DRAINAGE INFORMATION SHEET

PROJECT TITLE: COTTRELL'S FARM ZONE ATLAS/DRNG. FILE #: U12/TD8
 DRB #: 94-520 EPC #: _____ WORK ORDER #: _____
 LEGAL DESCRIPTION: LOTS 1-4, COTTRELL'S FARM
 CITY ADDRESS: 1803 BRIDGE SW
 ENGINEERING FIRM: JEFF MORTENSEN & ASSOC. CONTACT: JEFF MORTENSEN
 ADDRESS: 6010-B MIDWAY PARK BLVD NE PHONE: 345-4250
 OWNER: BEATRICE COTTRELL CONTACT: _____
 ADDRESS: 1803 BRIDGE SW PHONE: 242-1752
 ARCHITECT: N/A CONTACT: _____
 ADDRESS: _____ PHONE: _____
 SURVEYOR: JEFF MORTENSEN & ASSOC. CONTACT: JEFF MORTENSEN
 ADDRESS: 6010-B MIDWAY PARK BLVD NE PHONE: 345-4250
 CONTRACTOR: N/A CONTACT: _____
 ADDRESS: _____ PHONE: _____

RE: DRAINAGE PLAN FOR COTTRELL'S FARM, (L12/D8), (PWD-94-286),
SUBMITTED FOR FINAL PLAT APPROVAL, ENGINEER'S STAMP DATED
11/17/94.

DRAINAGE PLAN **LOTS 1 - 4, COTTRELL'S FARM**

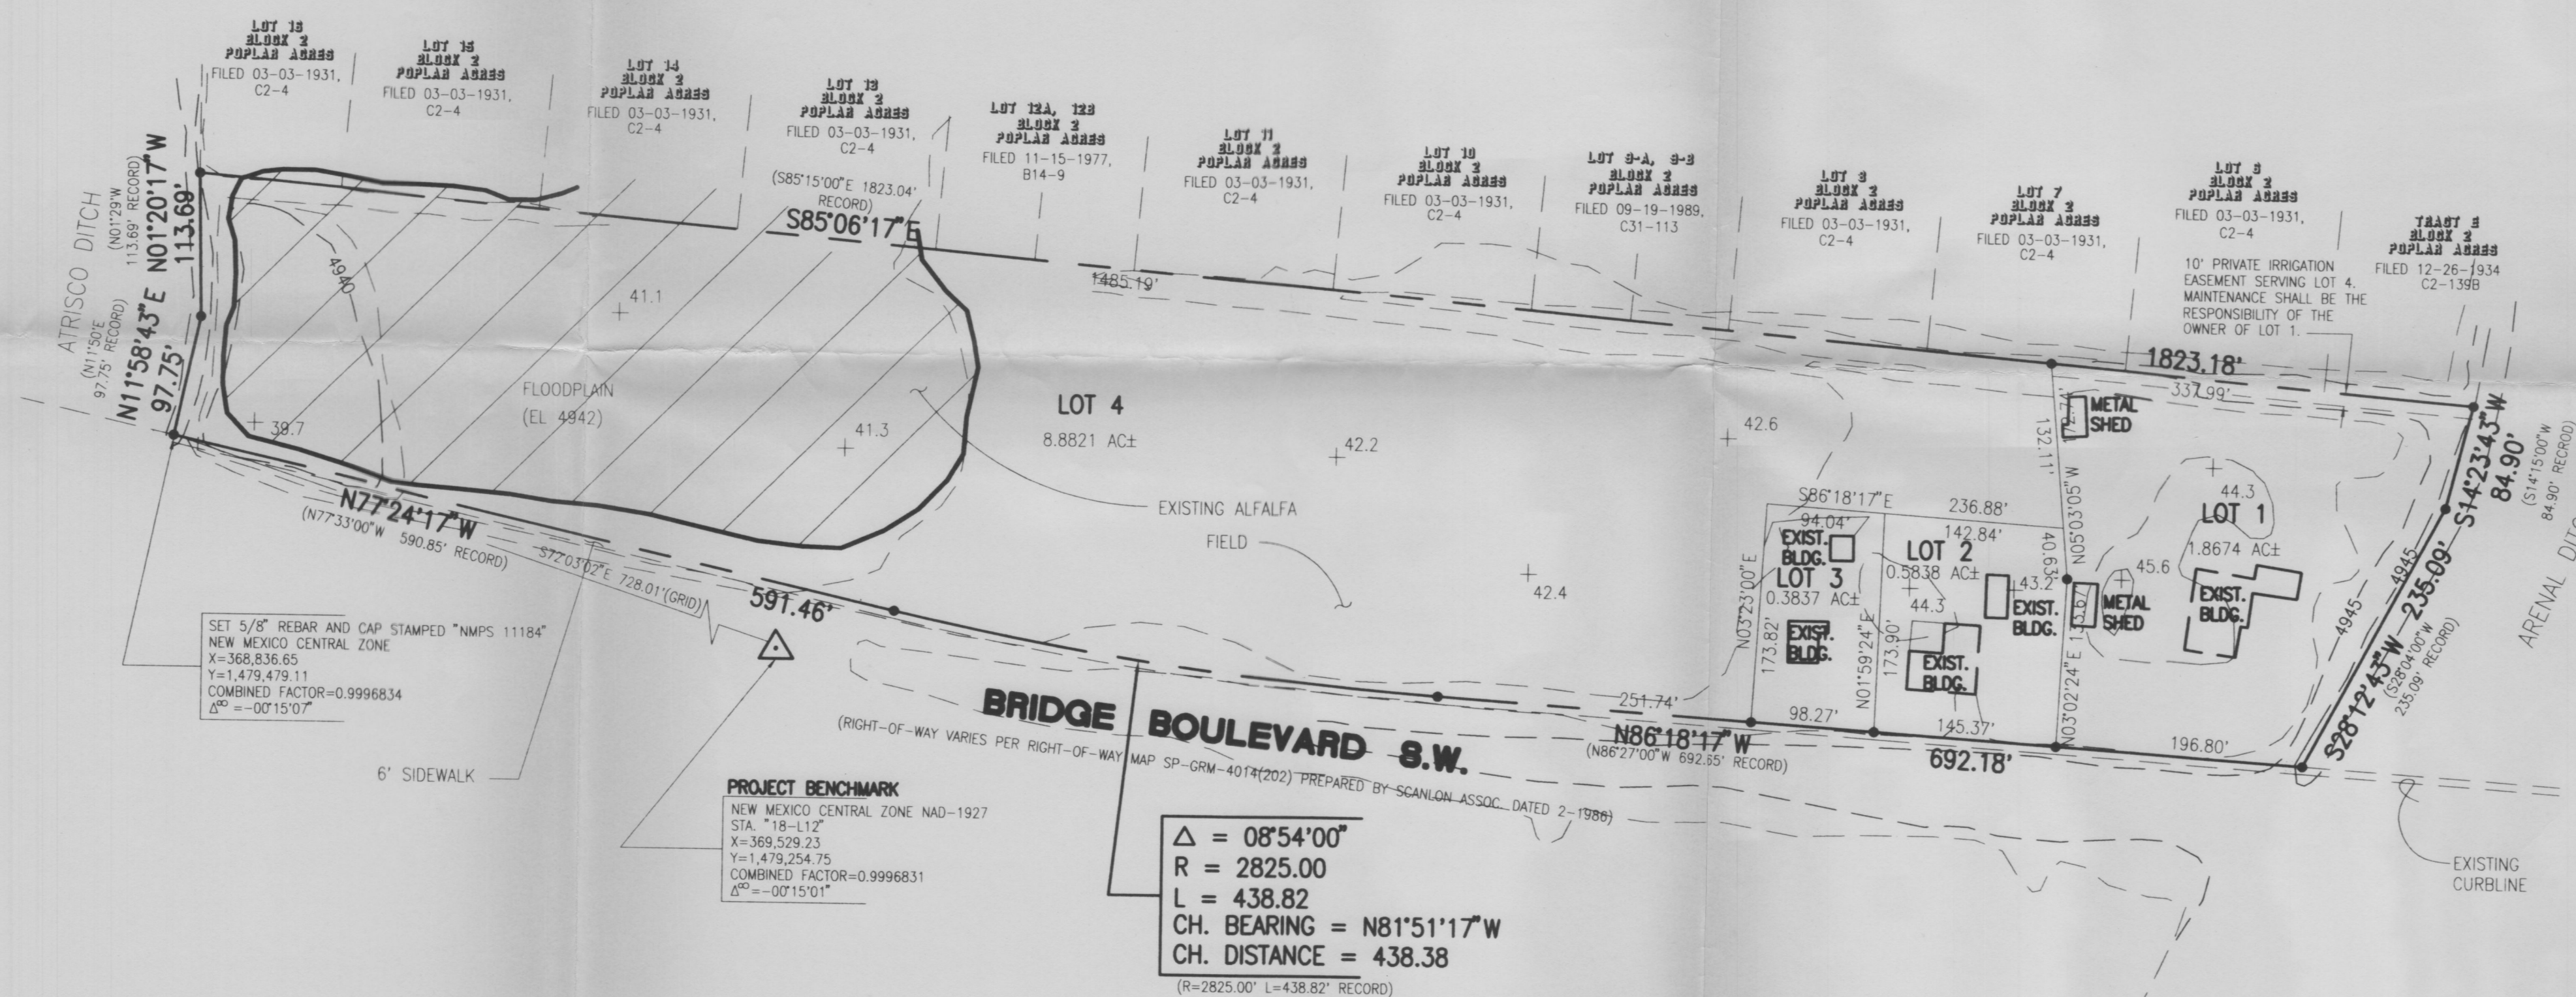
1. Since a portion of Lot 4 is within the 100-year flood plain as designated by FEMA, the plat should include the standard flood plain note. In the event that this lot is developed in the future, the property owner must comply with the County's Flood Damage Prevention Ordinance (No. 88-46), and all FEMA regulations. Please provide a copy of the plat.
2. The drainage plan must contain the standard Engineer's statement regarding site inspection as outlined in the County Ordinance. This statement must be signed and dated.
3. It appears that there may be an error in the peak discharge calculations.

1. Please include the standard engineering statement regarding site inspection as outlined in the County Ordinance. The statement must be signed and dated.
2. It appears that there may be an error in the peak discharge calculations.

Enclosed you will find a copy of the plat. Per previous direction at the DRB, the "standard floodplain" has been already incorporated onto the document. The standard engineer's certification was inadvertently overlooked due to the fact that the submittal was made to the "City" and not the "County". We are now aware that a Memorandum of Understanding has been issued whereby all submittals of this nature should be submitted to the County. Lastly, a typographical error was noted in the calculations. This has been corrected; thank you for bringing this to our attention.
